WALBERTON PARISH COUNCIL
INCLUDING FONTWELL AND BINSTED
Parish Council Office, The Pavilion, The Street,
Walberton, Arundel, West Sussex, BN18 0PJ

21 June 2022

REF: Planning Application WA/50/22/PL, Land adjacent to Oak Bank, Wandleys Lane, Walberton. BN18 0QR

Client:	Mr & Mrs Corbett Oak Bank Wandleys Lane Walberton West Sussex BN18 0QR		
Project:	New dwelling on land adj Oak Bank, Wandleys Lane		
Drawing Title:	Proposed Feasibility Sketch Plan and Elevation		
Scale:	1:100/1:1250	Date:	Aug '21
Drawing No.:	21034/001P		Author: NRS
		Revision:	F

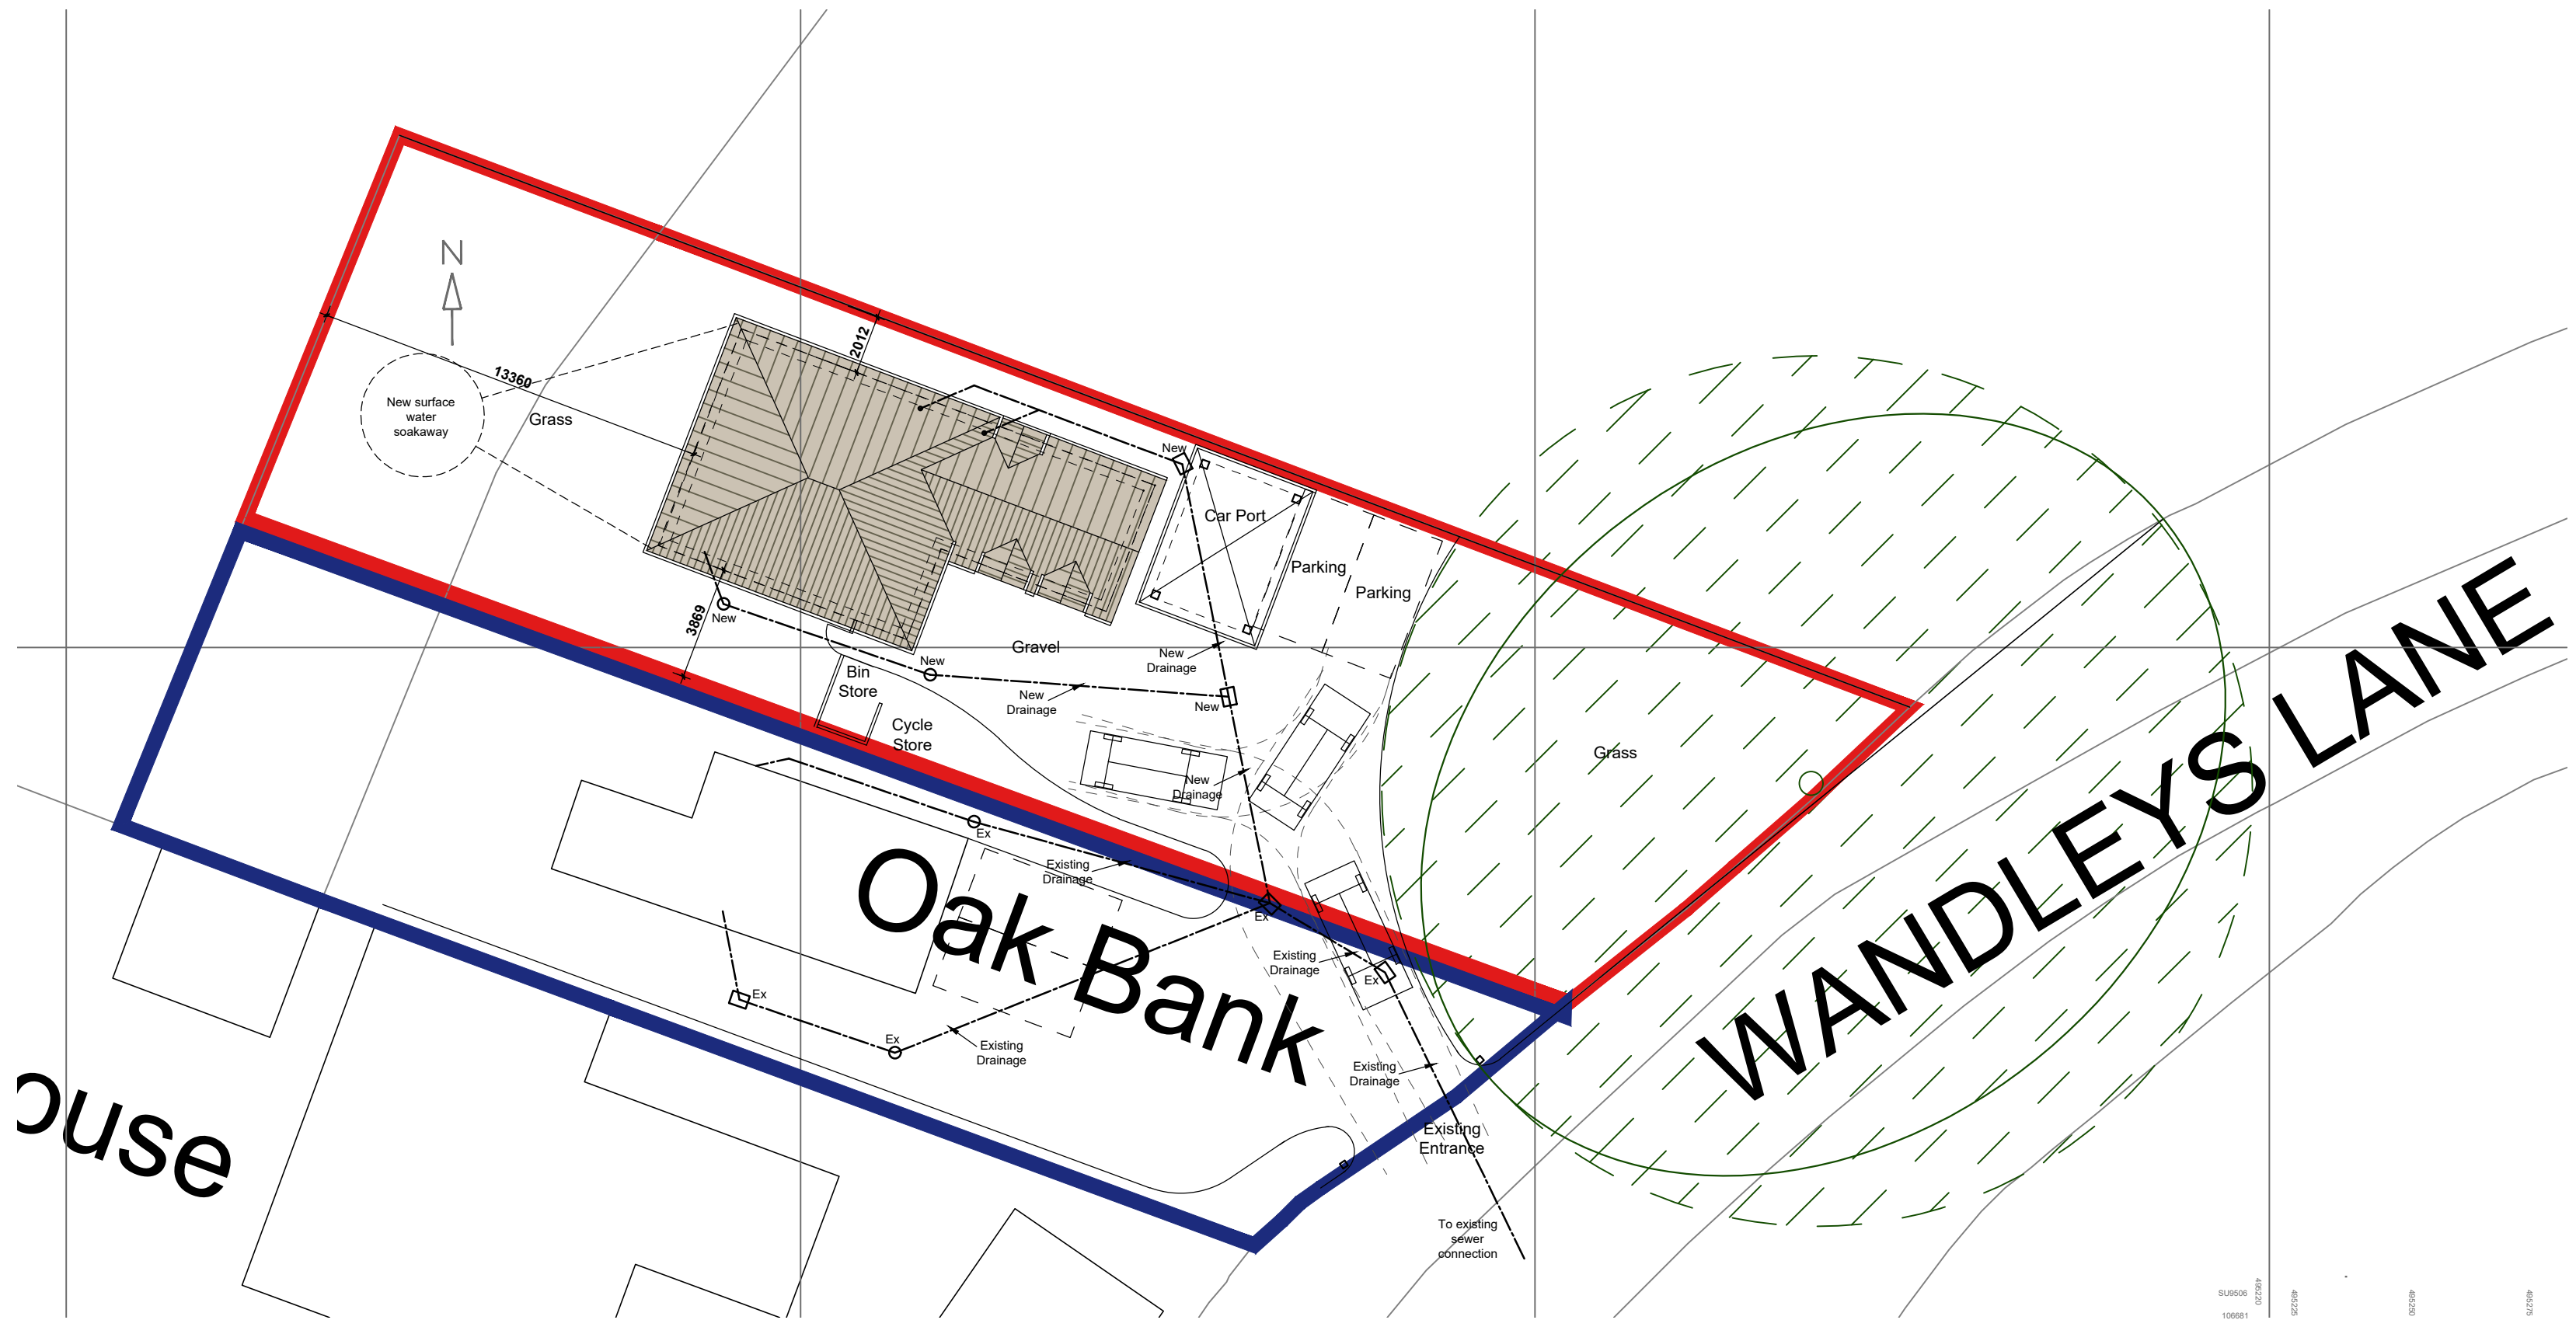
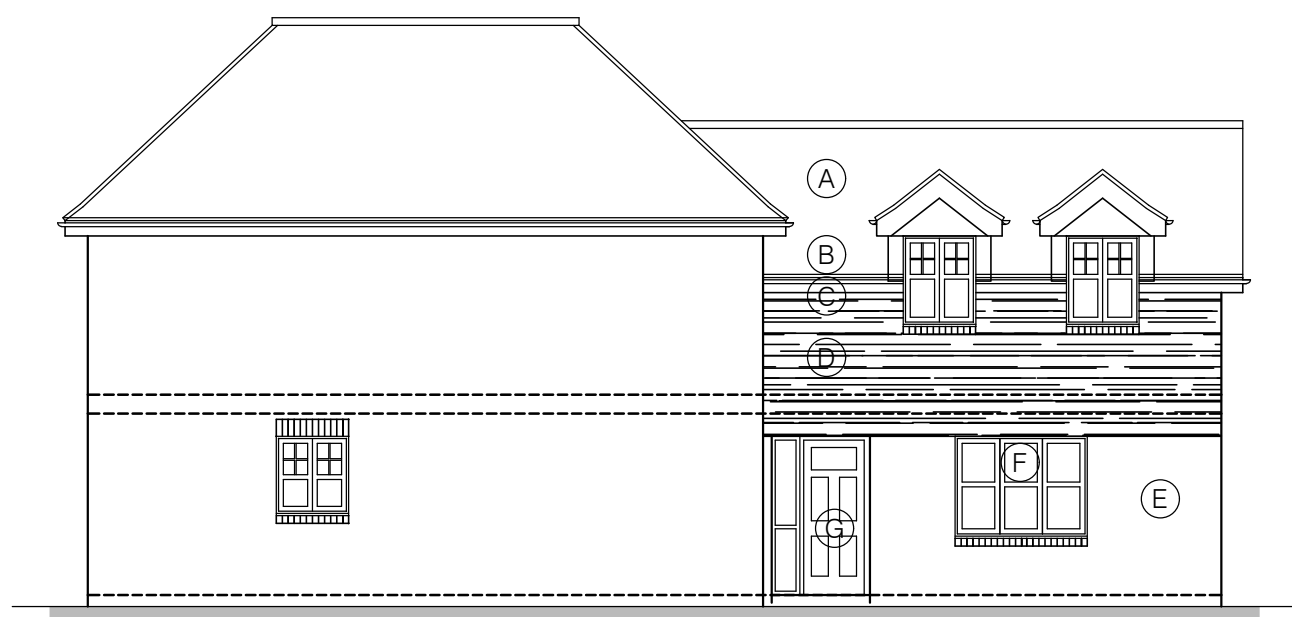
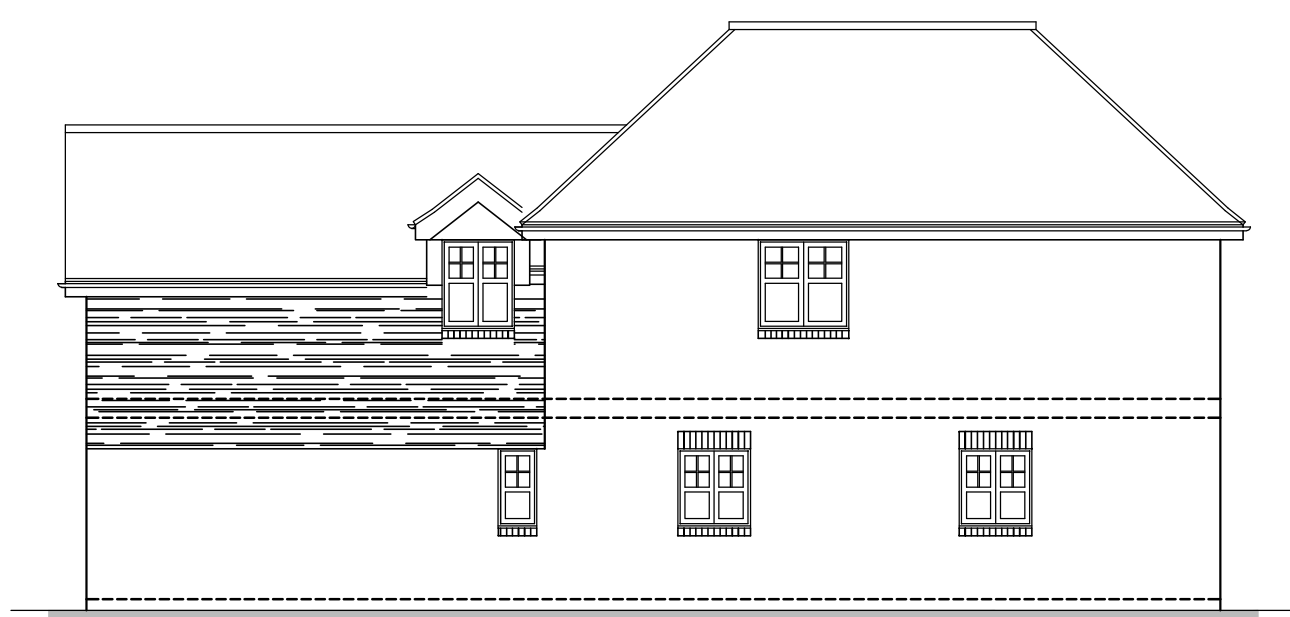
- We note that the pre-application recommendation is that one section of the dwelling by the site boundary be single storey to aid compliance with Arun Policy D SP1 and Walberton Neighbourhood Plan Policy HP13. This still does not appear to be the case on the plans presented.

- An electric car charging point is recommended, as per Arun Parking Standards SPD for dwellings of this type with off-street parking permission. None is indicated on the plans.
